DOC19/119005, EF13/3278

14 February 2019

**Brandy Hill Quarry Expansion Project SSD 5899
Comments on the Response to Submissions Revised Air Quality Impact Assessment**

ATTACHMENT A – EPA COMMENTS ON THE REVISED AIR QUALITY IMPACT ASSESSMENT

Figure 6-4: PM_{10} Concentrations at Beresfield [DECCW, 2014]

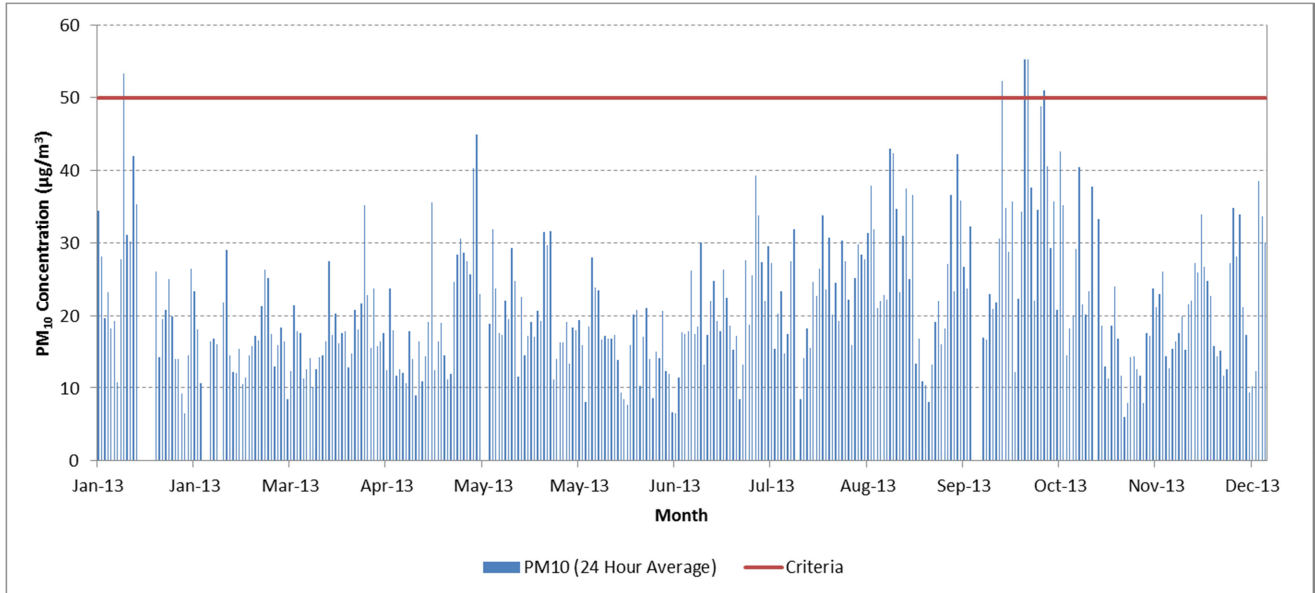
Background concentrations for cumulative analysis was obtained from the OEH Beresfield station. Concentrations above the 24-hour average PM₁₀ criterion of 50 µg/m³ in the background data were removed. There was no rationale provided for removing data from the background dataset. The contemporaneous method was used in assessing 24-hour average PM₁₀.

The dispersion modelling should include all days that had background exceedances. Results on these days should then be discussed within this context. Days where background exceeds the criterion should not be removed from the modelling set.

Figure 9-1: Number of Days the 24-Hour Average Incremental Predictions Exceed the PM₁₀ Criteria

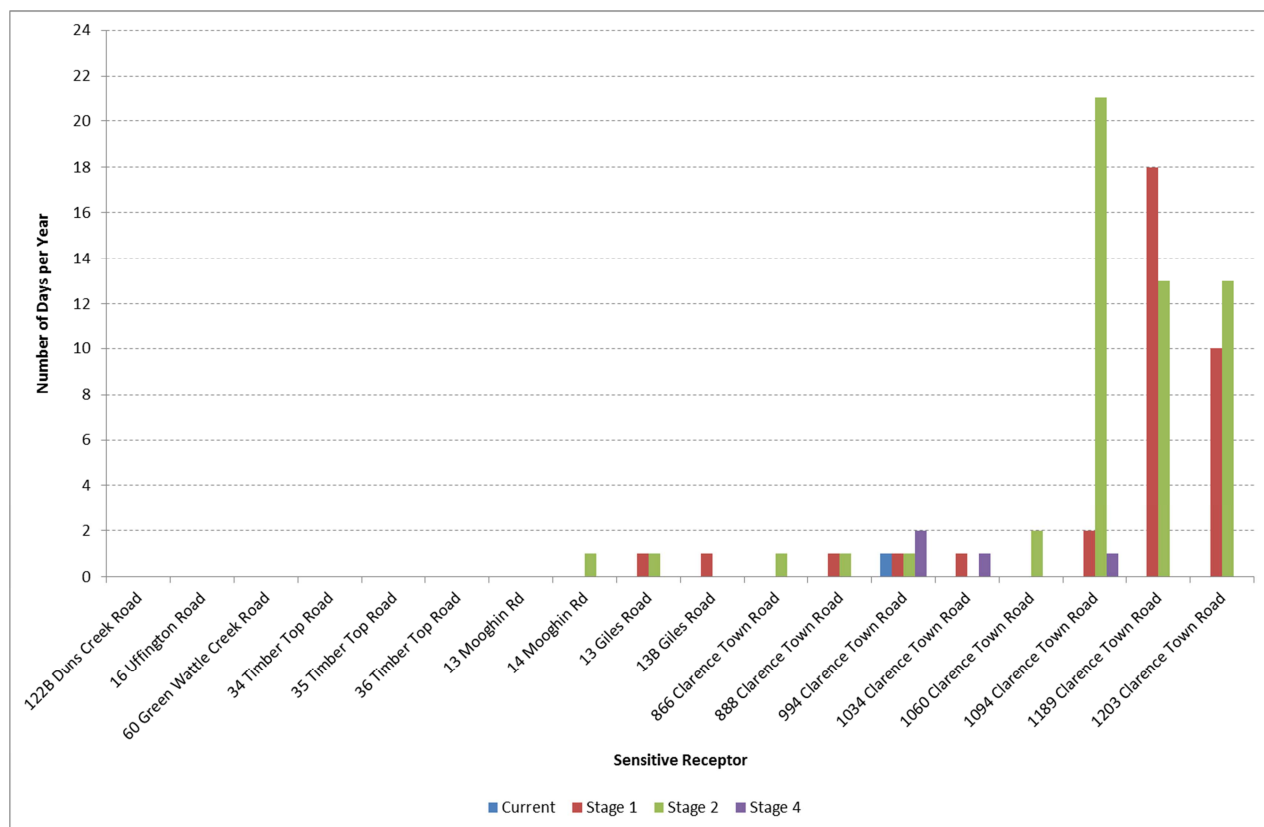
Based on the current assessment the EPA notes that the incremental air impacts are significant, and are above 15 µg/m³ at some receptors. Additionally, the maximum 24 hour average PM₁₀ concentration predicted at receptor R12 (49.6 µg/m³) only marginally complies with the EPA's impact assessment criterion of 50 µg/m³. Resolving the inconsistencies with the emissions inventory may increase predicted impacts.
